WEST SUSSEX COUNTY COUNCIL CONSULTATION

TO:	Arun District Council FAO: Amy Myer
FROM:	WSCC - Highways Authority
DATE:	11 November 2021
LOCATION:	Willmington Arundel Road Littlehampton BN16 4ET
SUBJECT:	A/227/21/OUT Outline application with all matters reserved (except access) for the erection of 7 No residential dwellings, vehicular & pedestrian access. This application is a Departure from the Development Plan.
DATE OF SITE VISIT:	n/a
RECOMMENDATION:	No Objection
S106 CONTRIBUTION TOTAL:	n/a

2021-6307-001

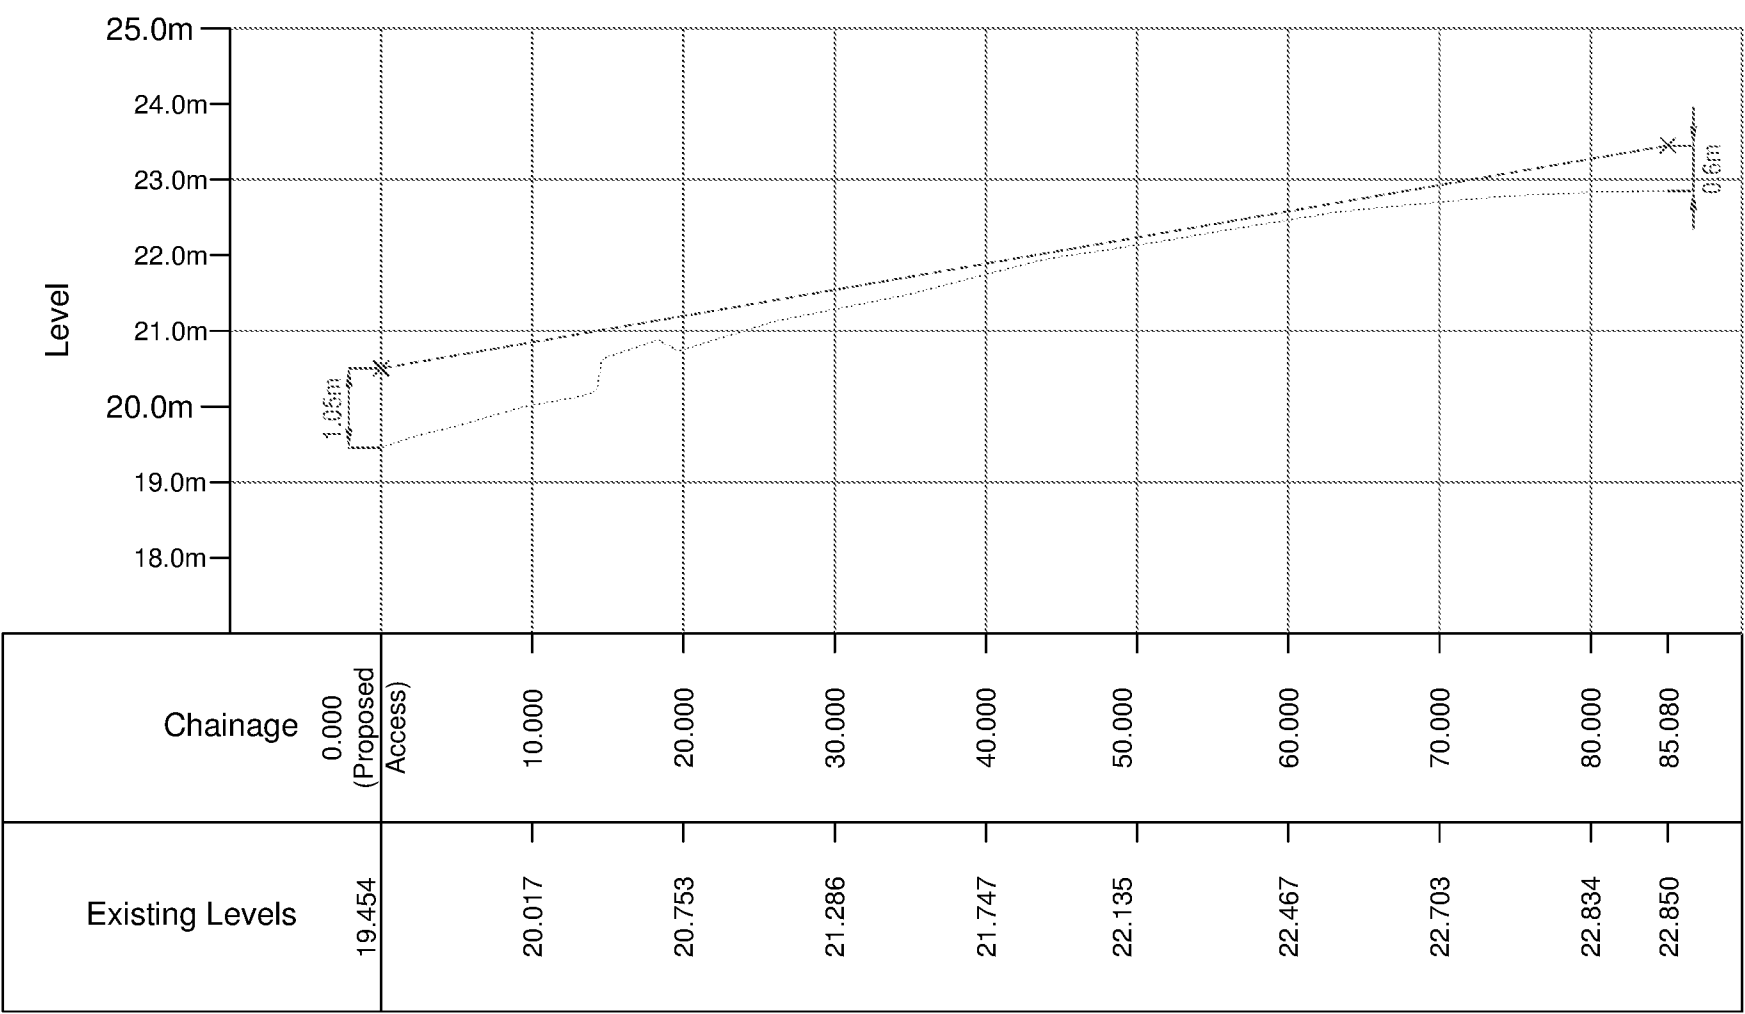
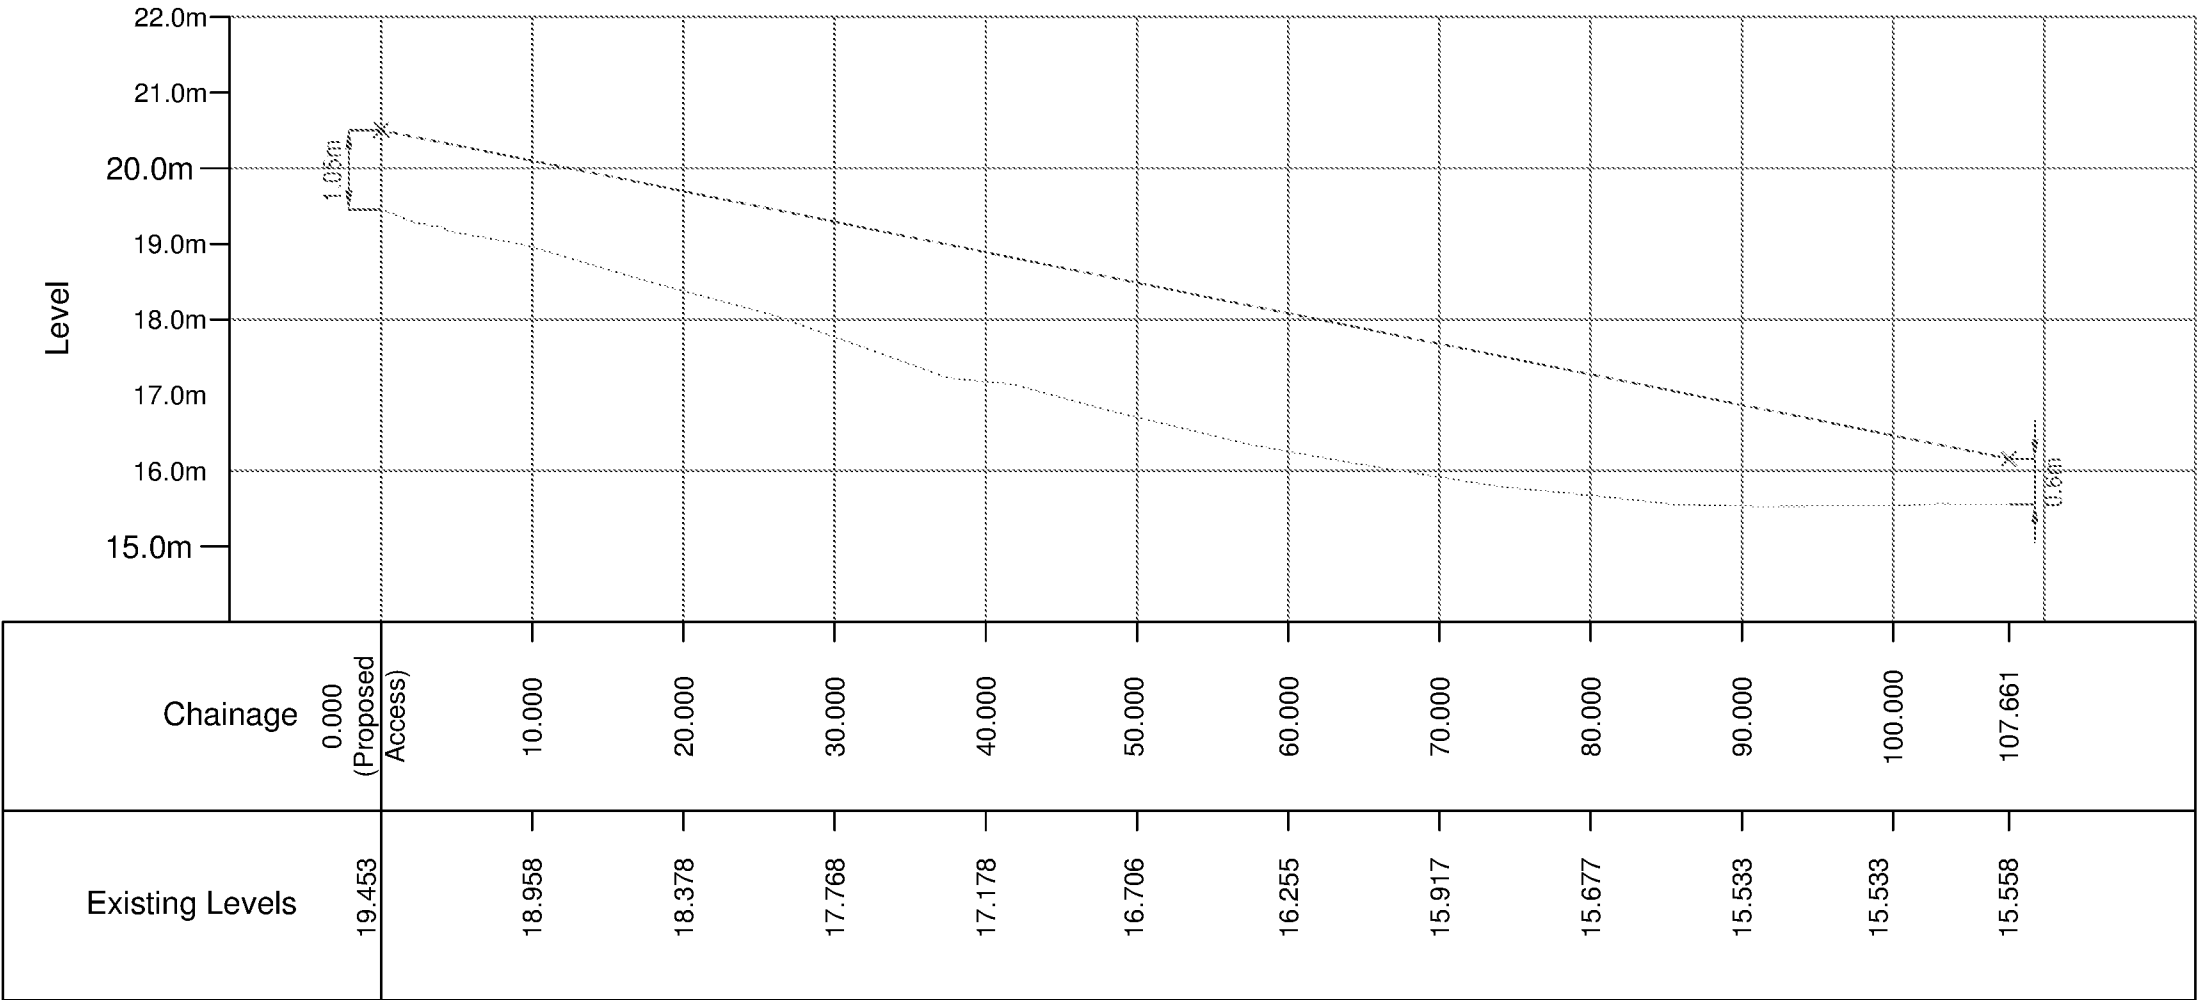
The proposed access arrangements are shown on Drawing 2021-6307-001, within the submitted Transport Statement. This includes the existing vehicular access to be closed off and a new vehicular access is taken from the location of the existing pedestrian access. A simple bellmouth priority junction 4.8 metre wide supported by 6.0 corner radii with tactile paving is proposed. This is to facilitate vehicles and pedestrian movements, in line with DMRB CD123 design requirements. A shared surface arrangement is considered appropriate for lightly trafficked access.

Visibility from the site access has been considered in line with the visibility requirements for the adjacent permitted development A/122/19/OUT. The transport assessment for planning application A/122/19/OUT identifies 85th percentile design speeds of 37mph. Drawing 2021-6307-001 within TS demonstrates maximum achievable visibility splays of 82.5m to the south and 107.5m to the north.

Visibility splays in both directions are in excess of the requirement 59 metre as per Manual for Street (MfS) requirements for a 37mph Design Speed.
